# CITY OF ALBUQUERQUE

May 2, 2024

**Re: CHICK-FIL-A**  
**5031 Montgomery Blvd. NE**  
**Traffic Circulation Layout**  
Engineer's Stamp 04-09-24 (F17-D034)

C-2.0

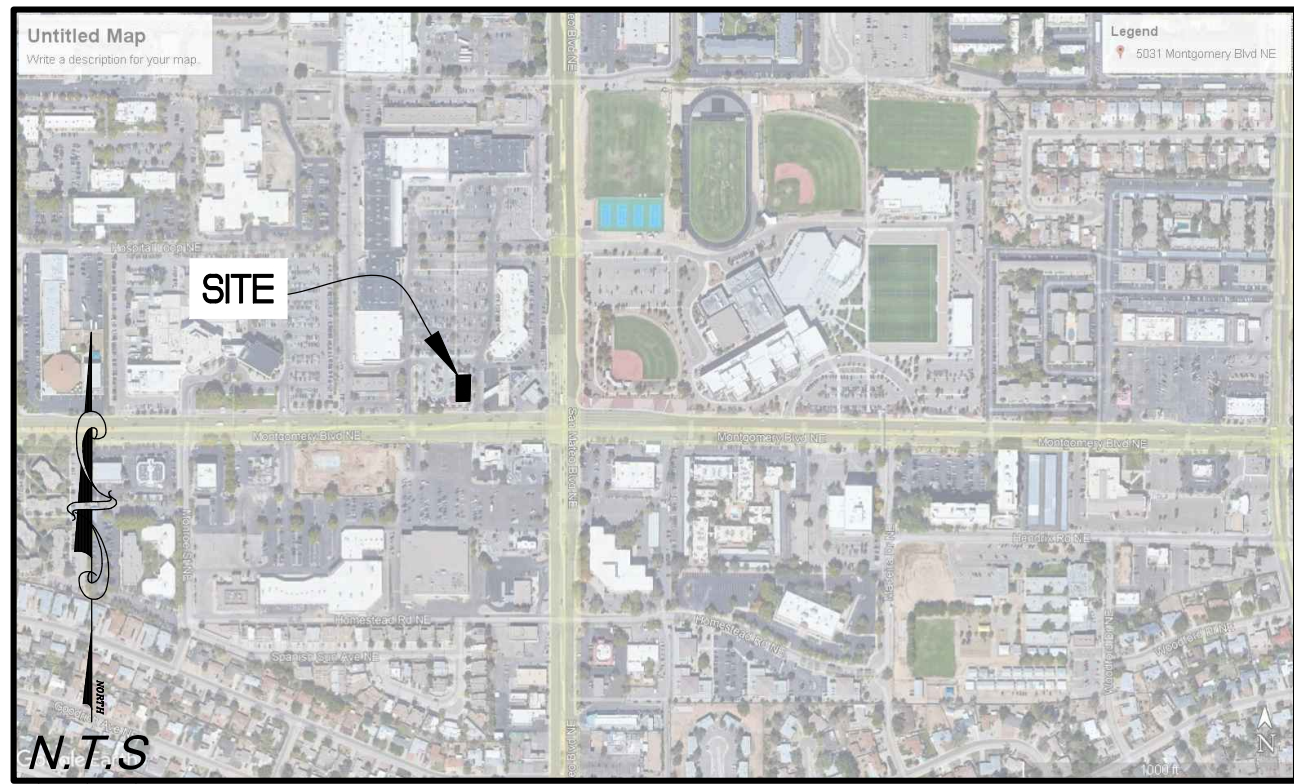
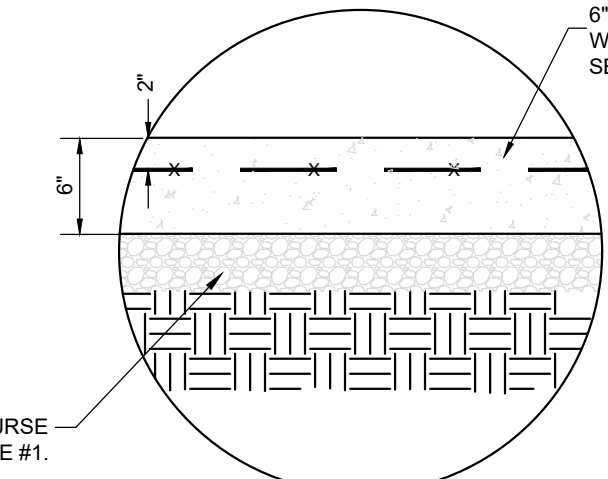
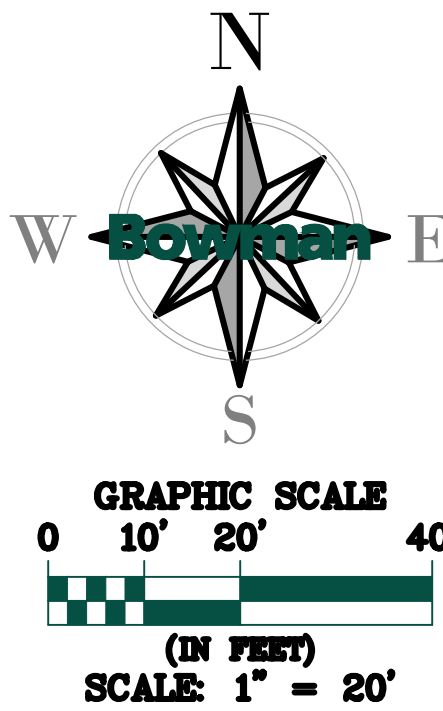
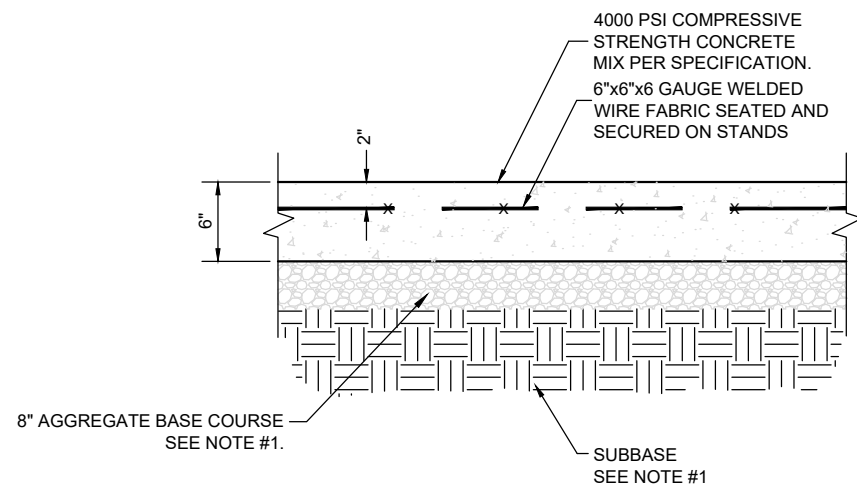
1. Please show a vicinity map on the site plan sheet C-2.0 showing the location of the development in relation to streets and well-known landmarks.
2. List the number of Motorcycle and Bicycle parking spaces required by the IDO.
3. Please show on the site plan, the required stacking spaces for the drive-thru lanes.
4. Please list the degree, width and length for all existing parking spaces. Some dimensions are not shown. See attached Angled Parking dimensions requirements for reference.
5. Show on the site plan the existing drive aisles width.

6. The ADA accessible parking sign must have the required language per 66-7-352.4C NMSA 1978 **"Violators Are Subject to a Fine and/or Towing."** Please call out detail and location of signs.

7. The ADA access aisles shall have the words **"NO PARKING"** in capital letters, each of which shall be at least one foot high and at least two inches wide, placed at the rear of the parking space so as to be close to where an adjacent vehicle's rear tire would be placed. (66-1-4.1. B NMSA 1978)

8. Please provide all the existing ADA ramps details (width, running and cross slopes). ADA curb ramps must be updated to current standards and have truncated domes installed.

9. The pavement marking "MC" should be shown in the opposite direction for motorcycles entering the parking space.
10. All bicycle racks shall be designed according to the following guidelines:

11. Bicycle racks shall be sturdy and anchored to a concrete pad.
12. A 1-foot clear zone around the bicycle parking stall shall be provided.
13. Bicycle parking spaces shall be at least 6 feet long and 2 feet wide.

14. Please show on the site plan these dimensions.

15. The minimum drive through lane width is 12 feet with a 25-foot minimum radius (inside edge) for all turns. (A 15-foot radius can be used with an increase in lane width to 14 feet). Please dimension all lane widths and radii.

16. Add a note stating "All broken or cracked sidewalk must be replaced with sidewalk and curb & gutter." A build note must be provided referring to the appropriate City Standard drawing.
17. Traffic Studies: See the Traffic Impact Study (TIS) thresholds. In general, a minimum combination of 100 vehicles entering and exiting in the peak hour warrants a Traffic Impact Study. Visit with Traffic Engineer for determination, and fill out a TIS Form that states whether one is warranted. In some cases, a trip generation may be requested for determination (**Contact Matt Grush: [mgrush@cabq.gov](mailto:mgrush@cabq.gov)**).
